Date: 13 December 2023
Our Ref: 12392

THE IMMINGHAM OPEN CYCLE GAS TURBINE ORDER 2020 (S.I. 2020 NO. 847) (THE 'ORDER')
PROPOSED APPLICATION FOR A NON-MATERIAL CHANGE ORDER IN RESPECT OF CHANGES TO SCHEDULE 12 'DESIGN PARAMETERS' OF THE ORDER

THE IMMINGHAM OPEN CYCLE GAS TURBINE (VPI 'B') PROJECT, LAND NORTH OF THE VPI COMBINED HEAT AND POWER ('CHP') POWER STATION, ROSPER ROAD, IMMINGHAM, LINCOLNSHIRE, DN40 3DZ

Schedule 12 dimension changes highlighted in blue

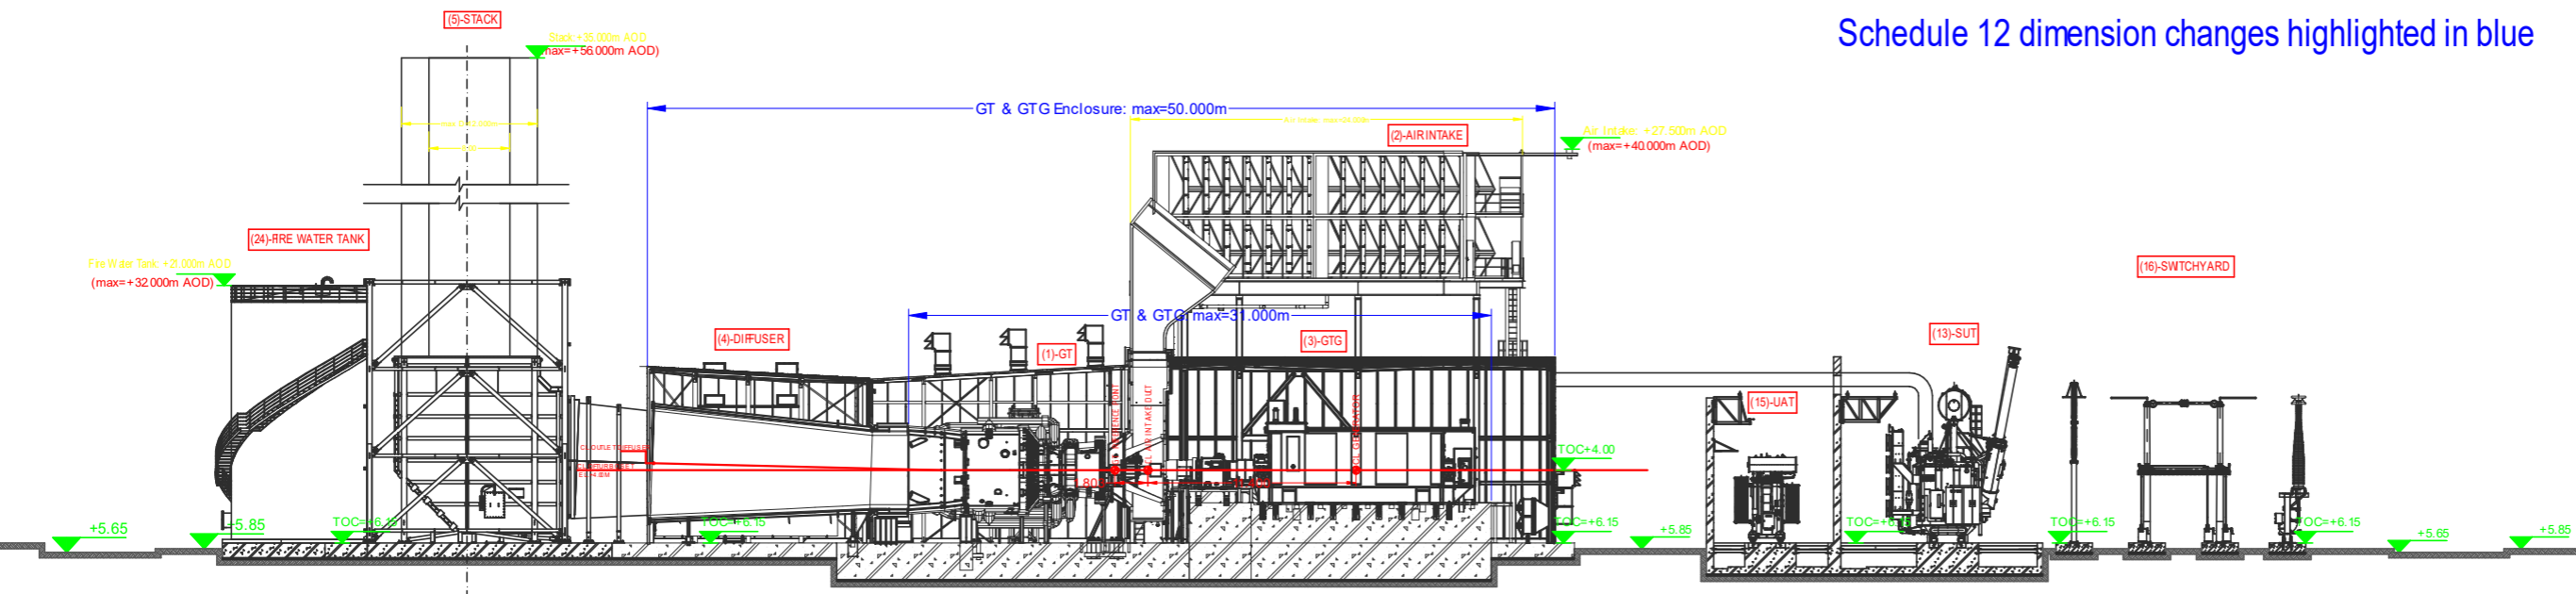
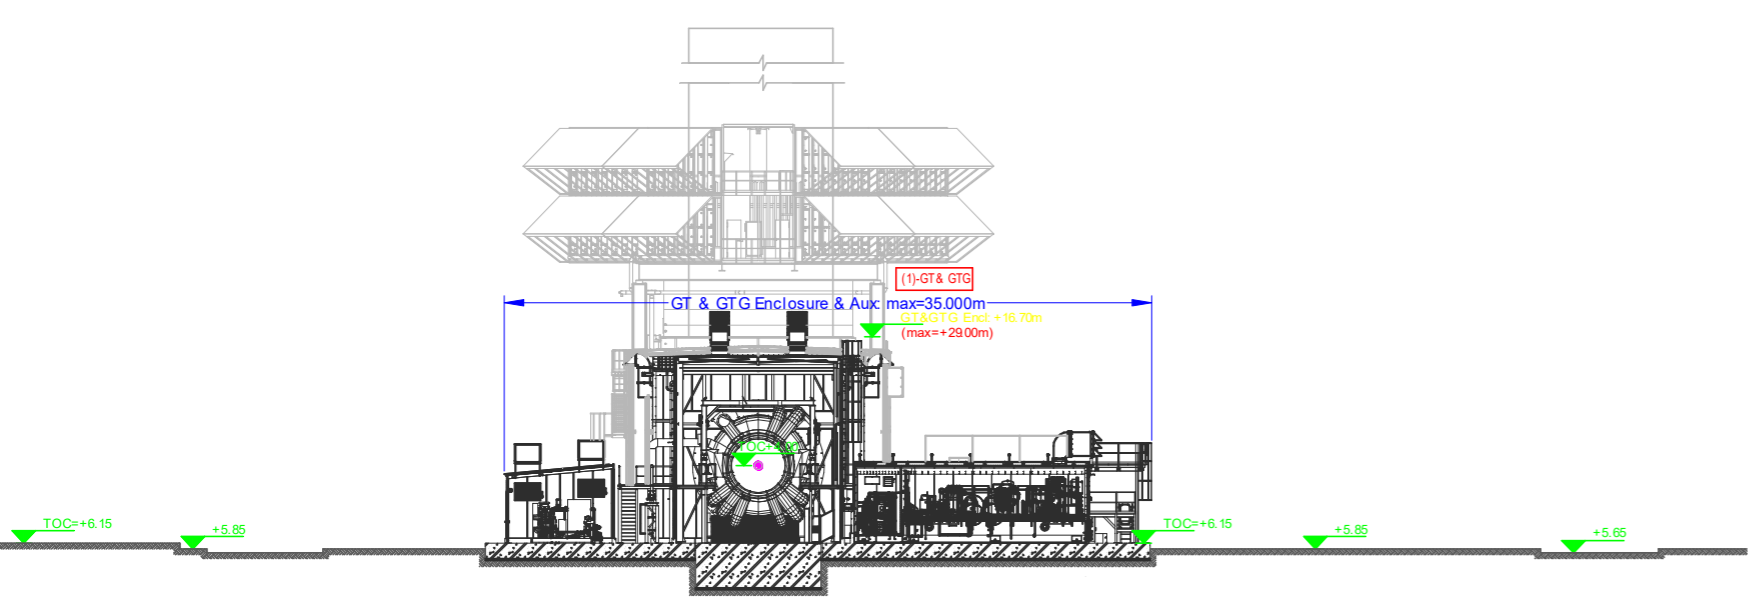
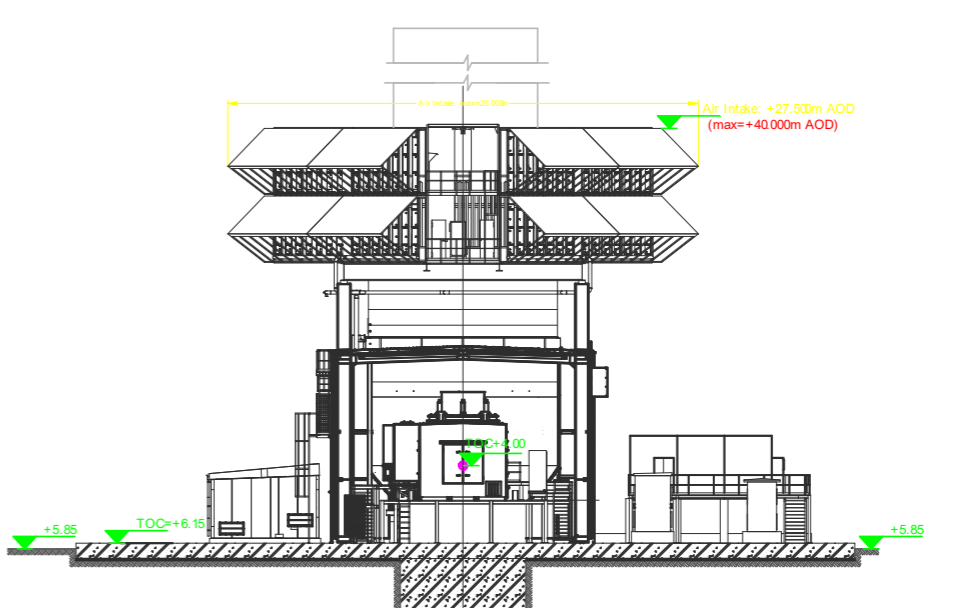
- **Single gas turbine and generator** - An update to the design of the gas turbine and generator has resulted in an increased length of 31 metres ('m') compared to 30m that was included in 'Schedule 12', 'Table 9 Design Parameters' of the Order.

- **Gas Turbine building** – The proposed update to the design incorporates a section of gas turbine diffuser (the exhaust duct) in the same building as the gas turbine and generator. In addition, certain items of auxiliary plant including fuel gas, hydraulic oil and instrument air systems, are now located adjacent and contiguous to the Gas turbine building and the Gas turbine building has been designed to incorporate and cover them. It is important to note that the items of auxiliary plant are not new or additional to Work No. 1, it is simply that their location has changed. Consequently, the Gas turbine building will be 50 metres long and 35 metres wide, compared to 46 metres long and 25 metres wide that was included in 'Schedule 12', 'Table 9 Design Parameters' of the Order.

The inclusion of the exhaust diffuser does not result in an increase in height or width of the gas turbine building but extends it by 1m. The adjoining of the auxiliary plant building to the Gas turbine building, although not part of the Gas turbine building does result in an increase in overall building width. It is however substantially lower in height than the height of the gas turbine building. The auxiliary plant is not additional to Work No. 1 of the Order but is simply located contiguous to the Gas turbine building therefore requiring a change to the dimensions.

| <i>(1) Building or structure</i> | <i>(2) Maximum length (metres)</i> | <i>(3) Maximum width (metres)</i> | <i>(4) Maximum height (metres above 0 meters above ordnance datum)</i> | <i>(5) Maximum diameter (metres)</i> |
|--|--|---|--|--|
| Single gas turbine and generator | 30 31 | 20 | 20 | - |
| Gas turbine building | 46 50 | 25 35 | 29 | - |
